TOWN AND COUNTRY PLANNING ACT 1990 FULL

Reference: H16-0172-22 **Date of Decision:** 13th April 2022
Applicant: Elegant Smiles
2 Woolram Wygate
Spalding
PE11 1NX
Location: 2 Woolram Wygate Spalding
Description: Proposed single storey extensions

Drawing Title:
PROPOSED GROUND FLOOR PLAN AND
ELEVATIONS.

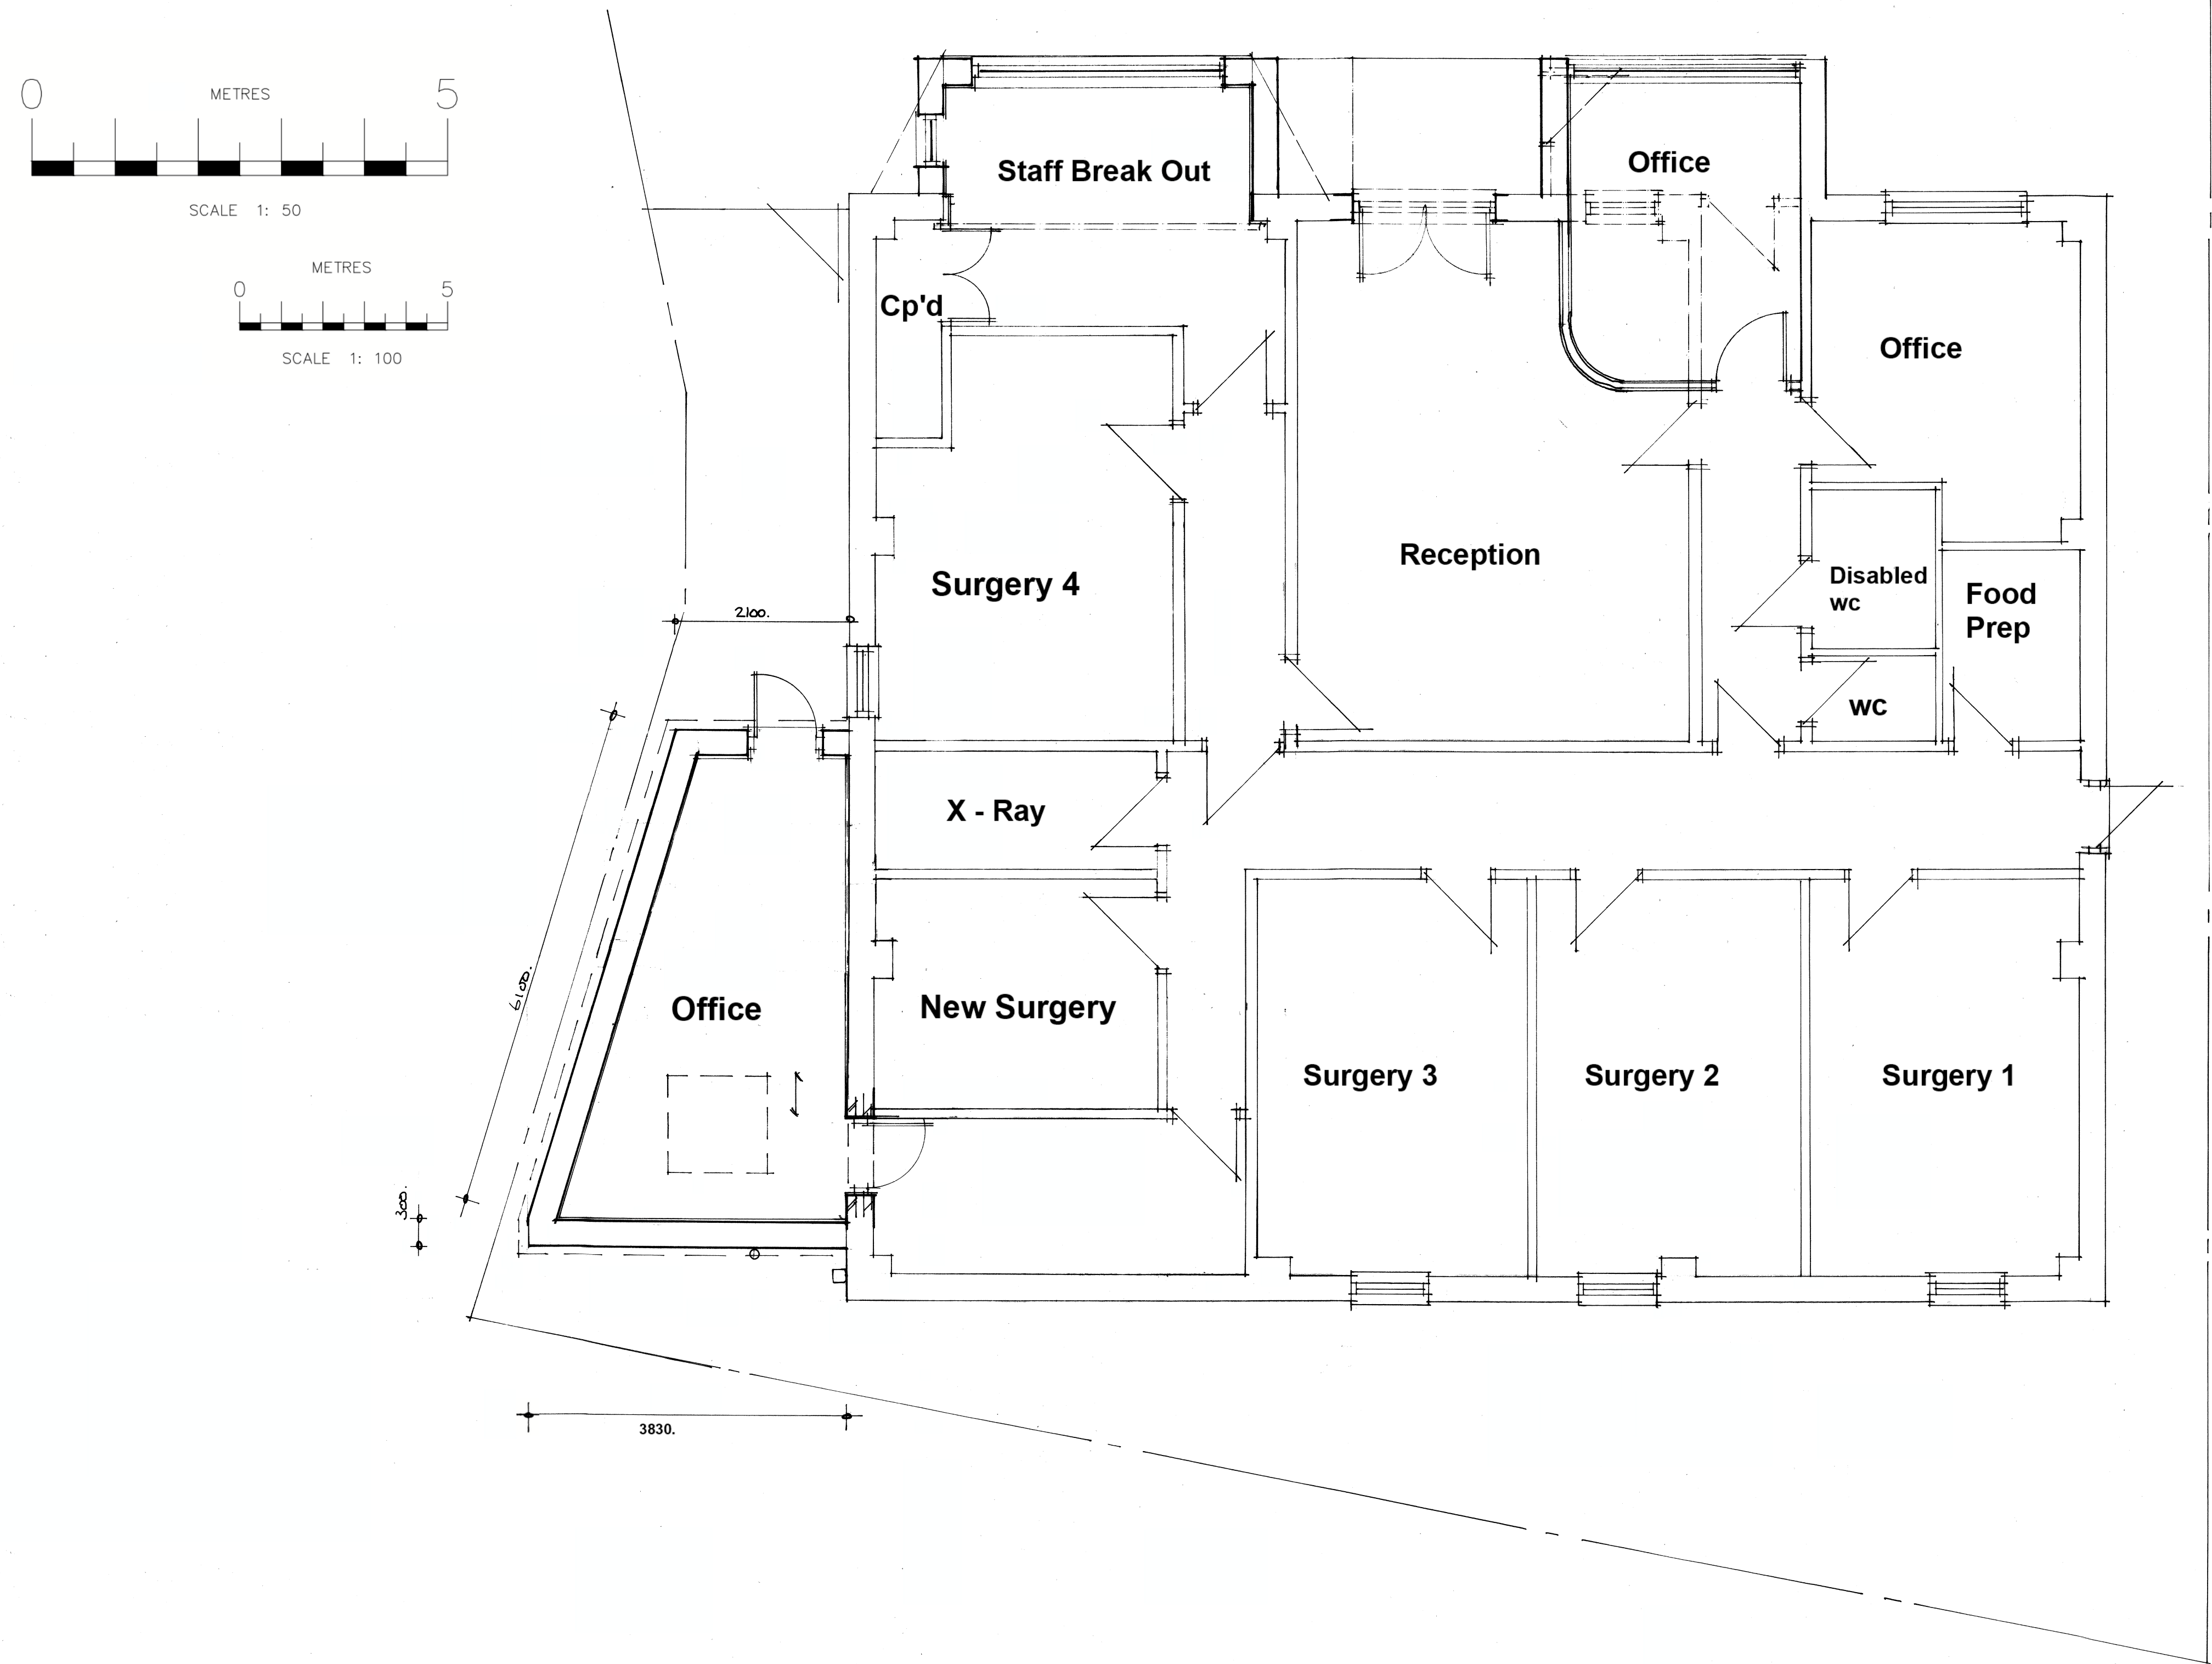
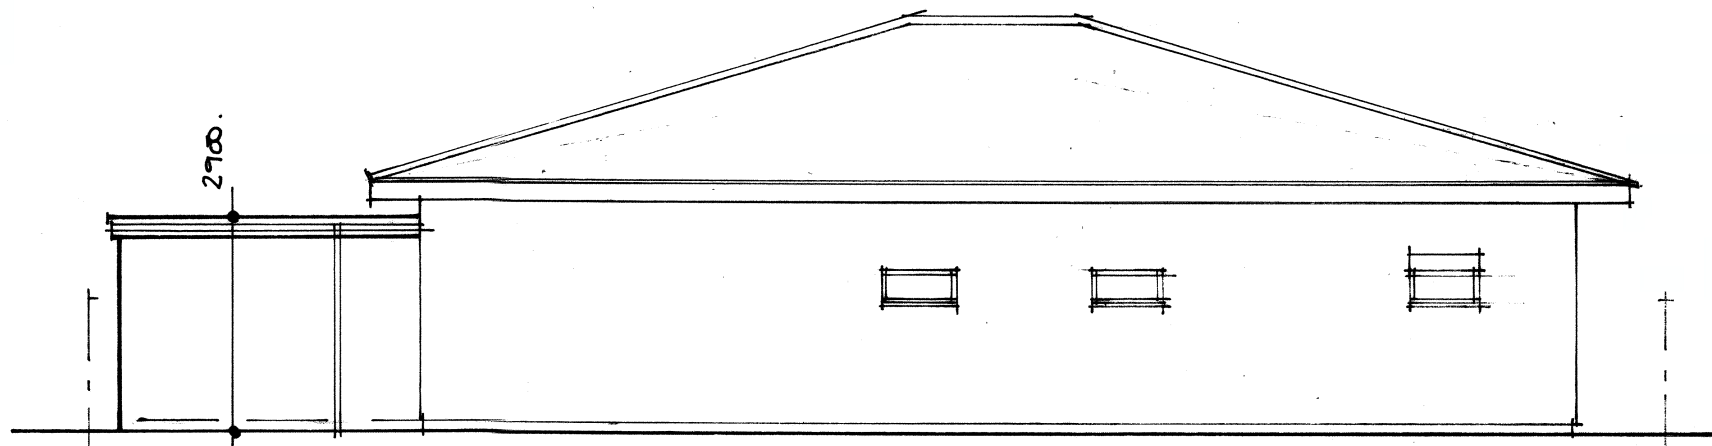
- 3 Notwithstanding the details submitted, the south facing window to the staff breakout area shall be obscure glazed using a minimum of Grade 3 glass and thereafter so maintained.
